Application Reference: 2025/1039

Site Address: Garden Cottage, The Avenue, Wortley, Sheffield, S35 7DB

Introduction: Replacement of timber framed sash windows and external doors (Listed Building Consent)

DETAIL SHOWING 25 mm DUPLEX BARS

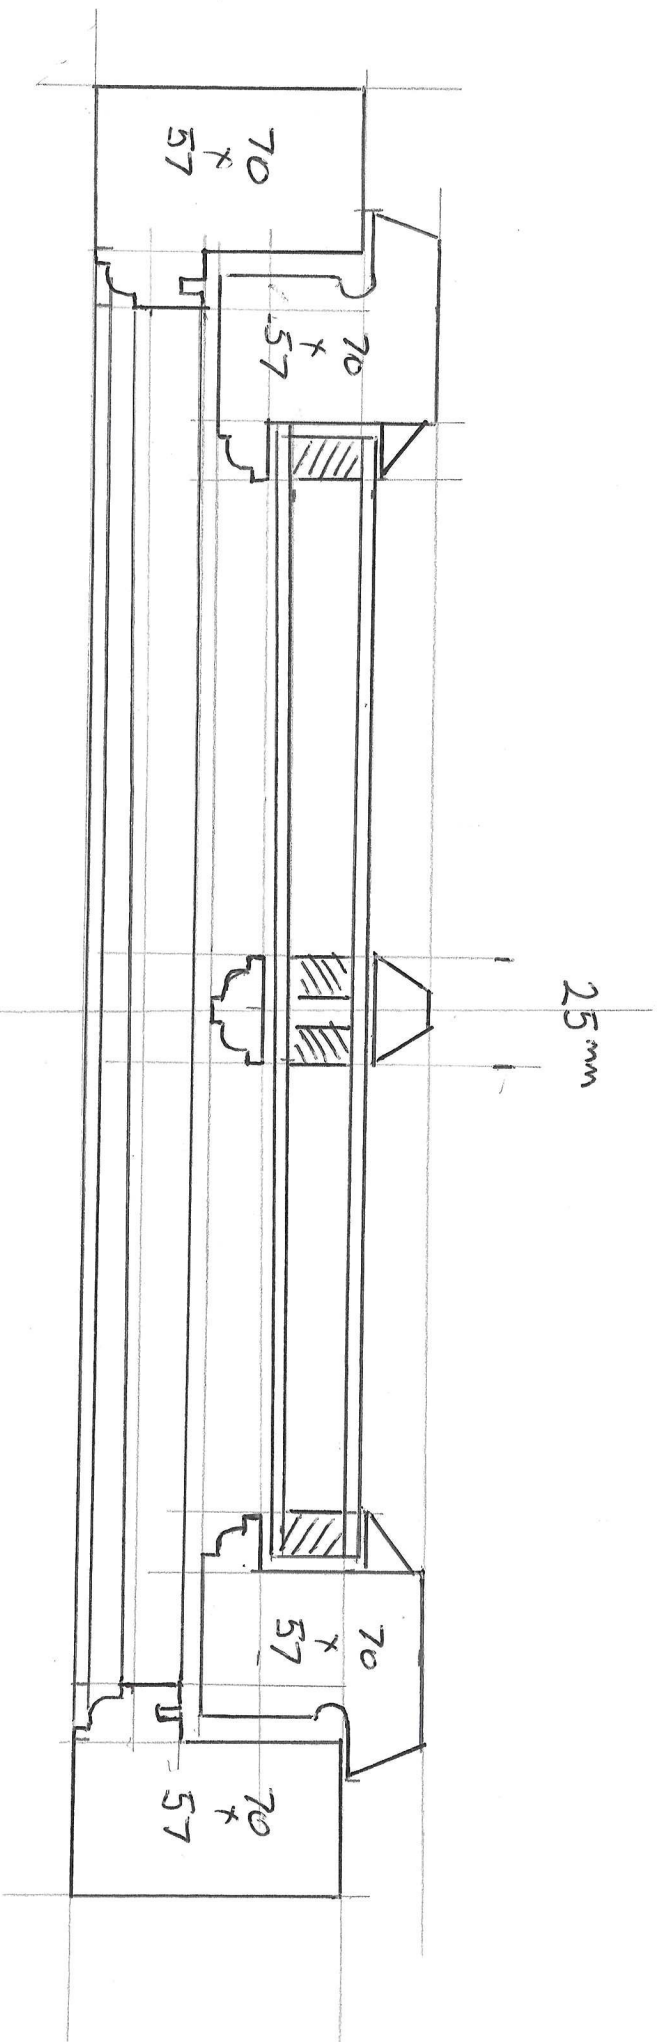
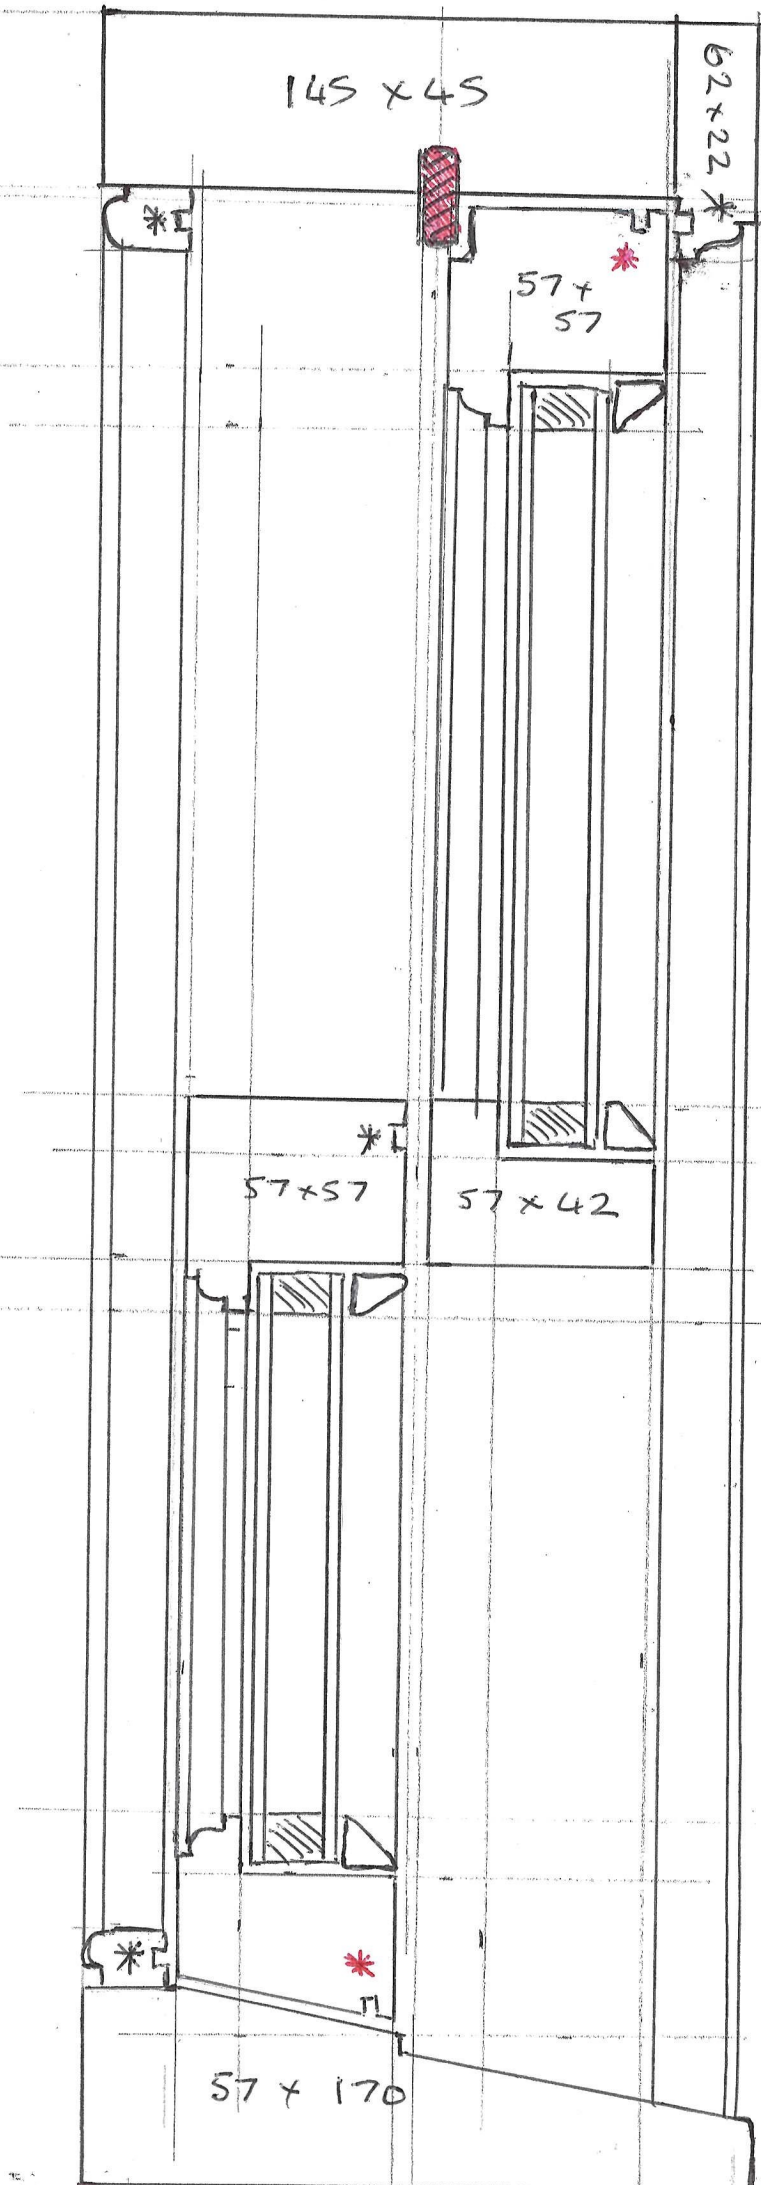
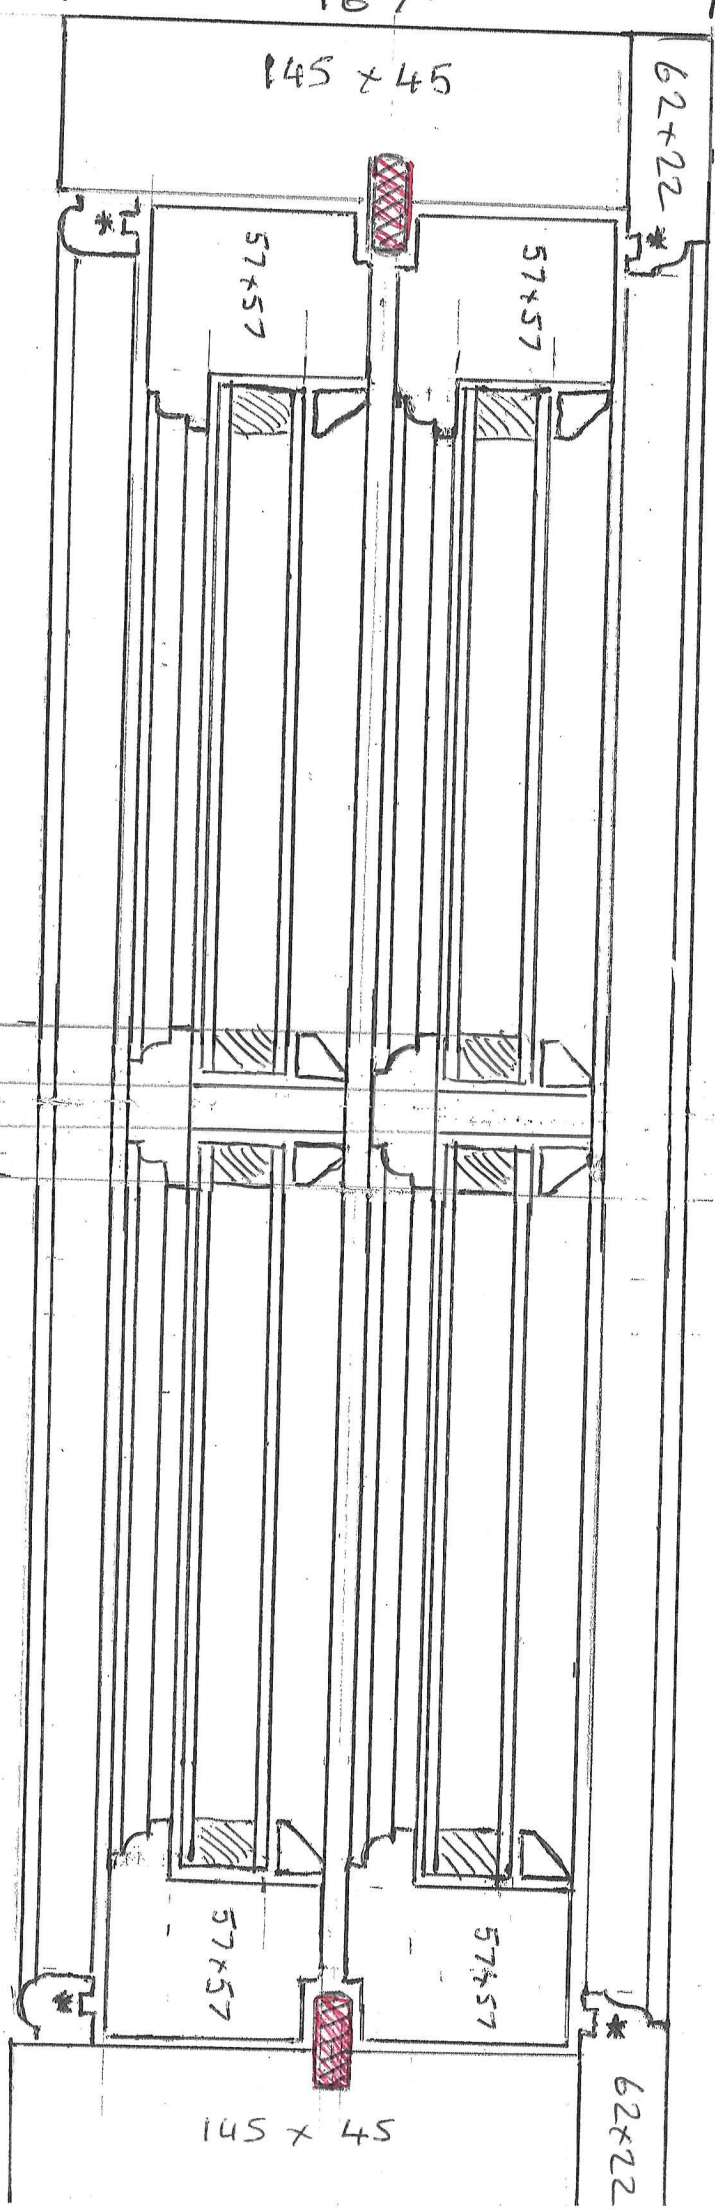
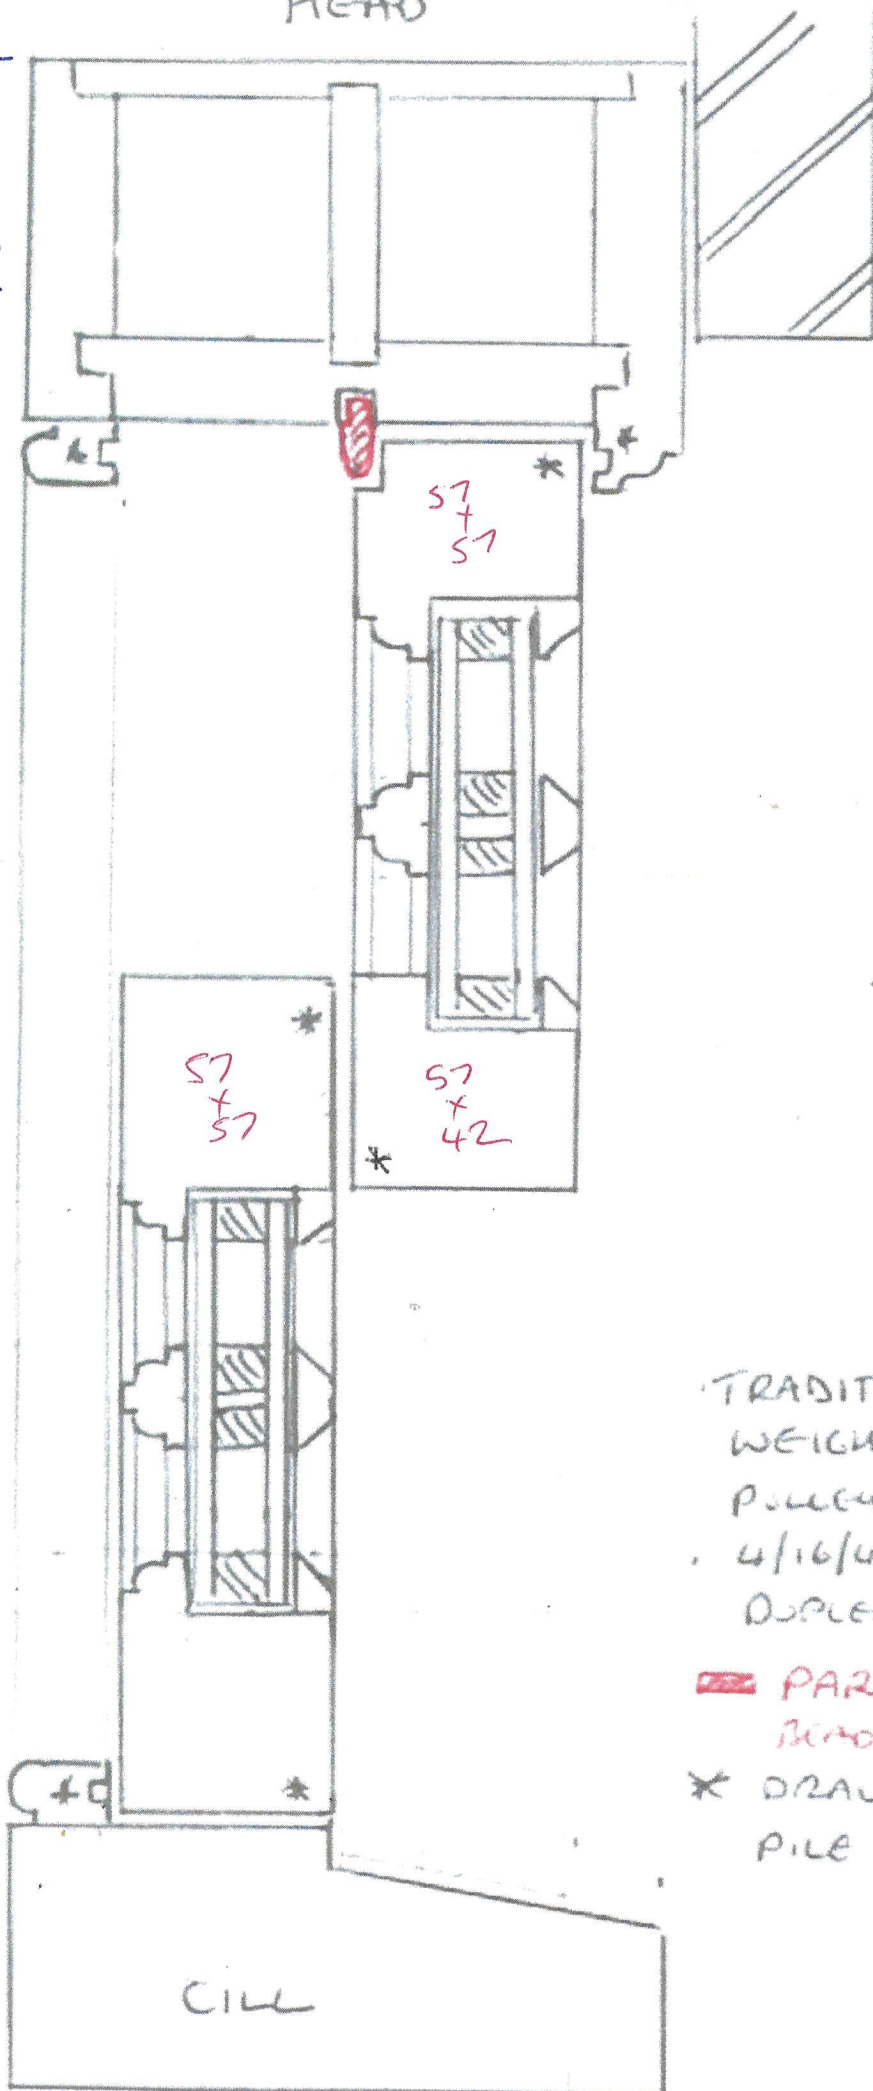
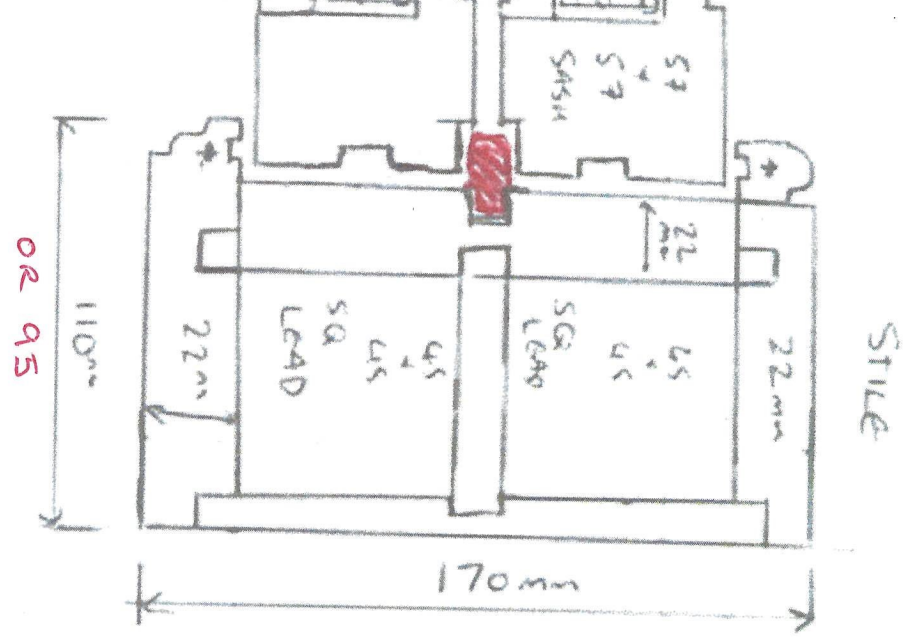
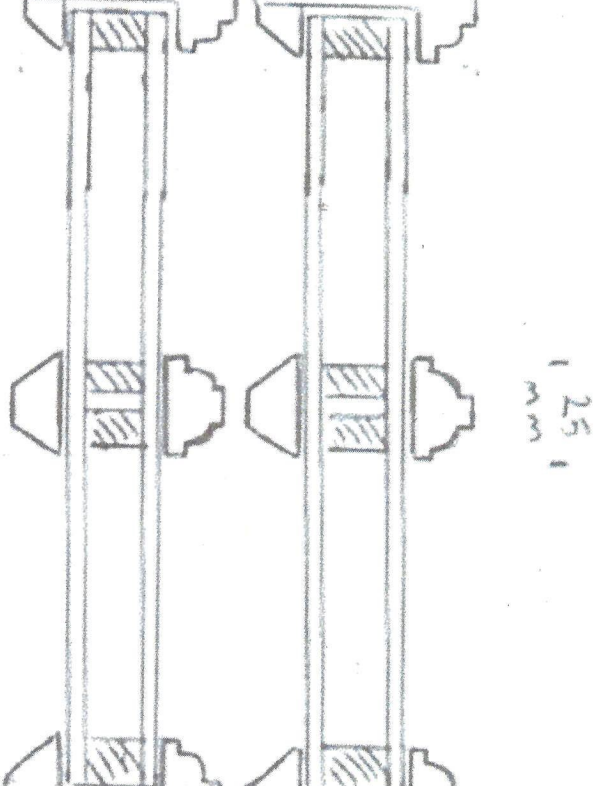
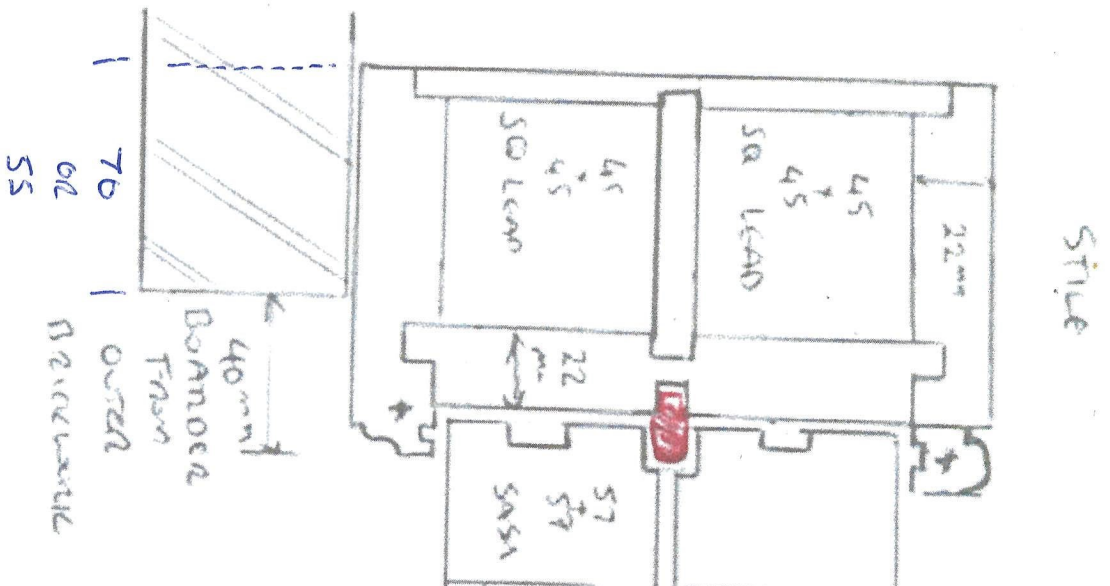
The proposal does not negatively affect the setting of the listed building, nor the visual amenity of the surrounding area. The proposed glazing has been amended after discussions between the conservation officer and the applicant and window manufacturer to ensure a slim 4/4/4 double glazed unit is used. This ensures the proposed windows are not overly chunky and acceptable sight lines are maintained. White warm edge spacers have been agreed which are more akin to the light green decoration of the frames. Additionally, the external moulding and decoration replicates the existing appearance and allows for a sympathetic appearance.

4. The double glazing shall utilise thin units with a maximum of 4mm outer glass, 4mm cavity, and 4mm inner glass resulting in an effective overall depth not exceeding 12mm.

5. The warm edge spacers shall be in white to reduce their visibility and improve sight lines.

6. The windows shall be sash in timber and decorated to match the existing, with spiral balances. All fixtures, fittings and furniture shall be satin to match existing.

Drawing Title: Elevations - Proposed

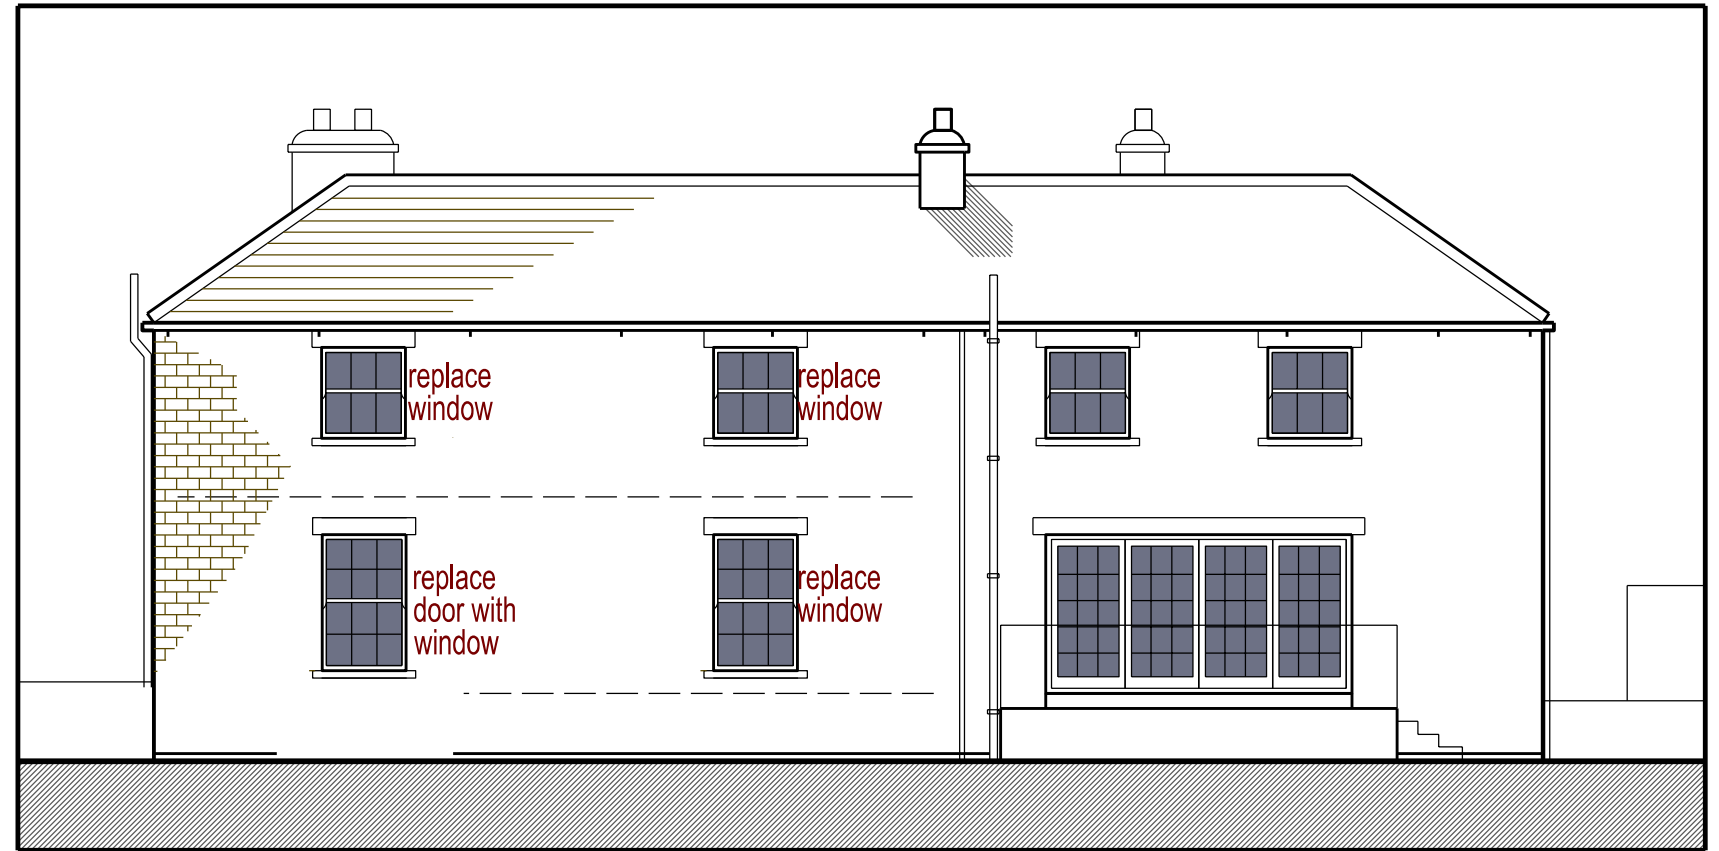
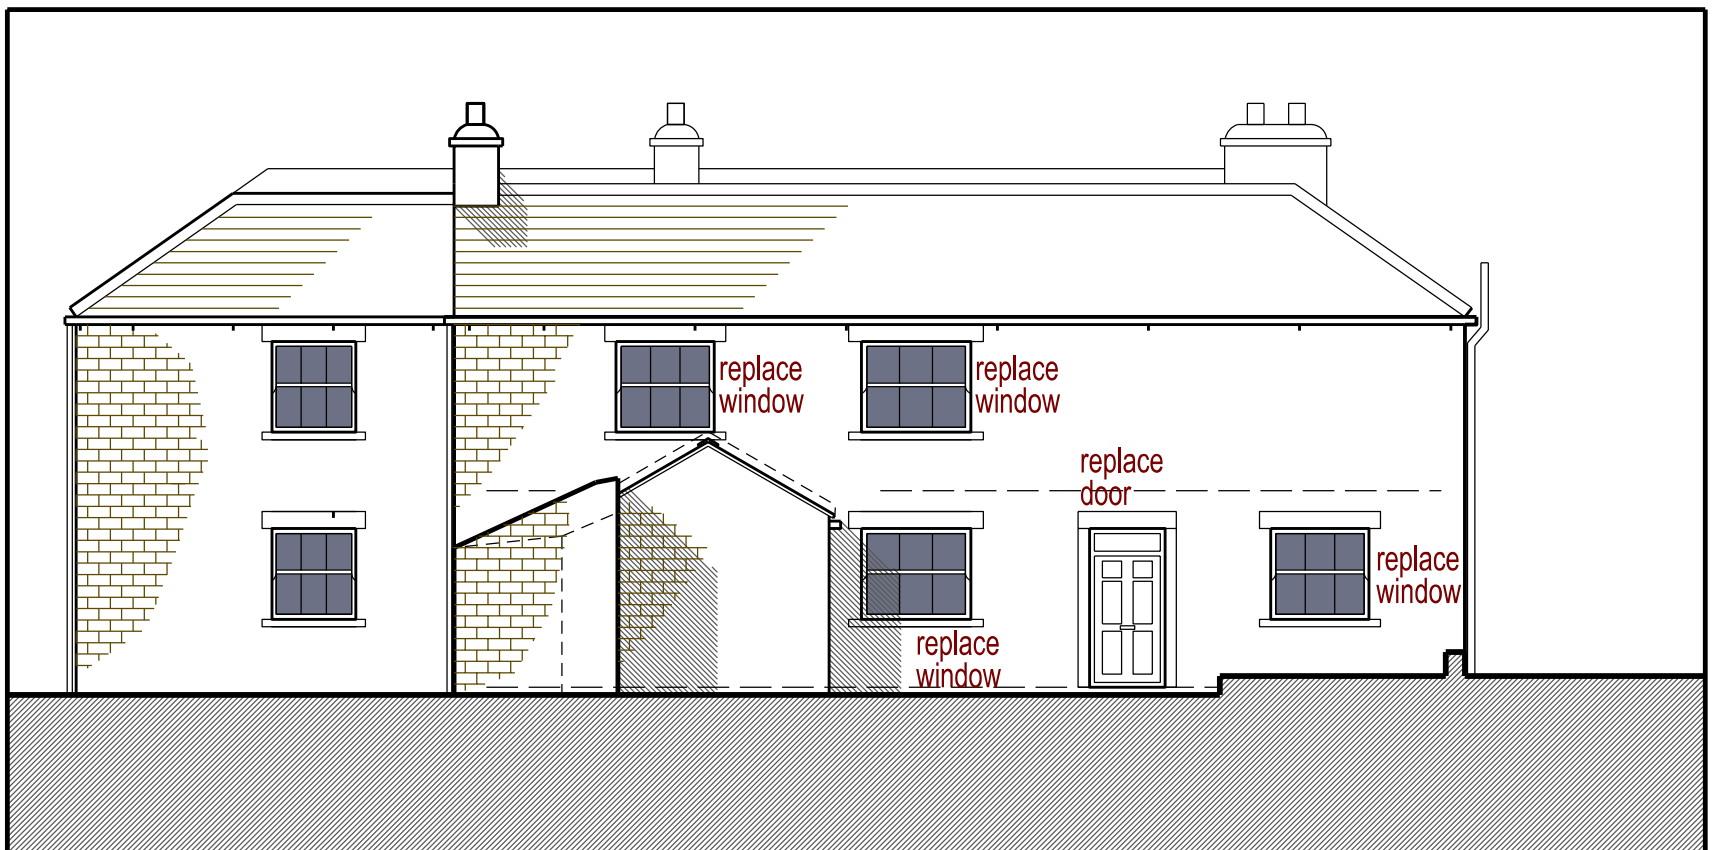
The conservation officer has been in close contact with the applicant, architect and window manufacturer to ensure the specific details of the window matches what would be considered acceptable. An additional proposed elevation was requested in order to show the change to the east elevation of the dwelling from the door replaced by a window. Elevations were received on the 30th January 2026.
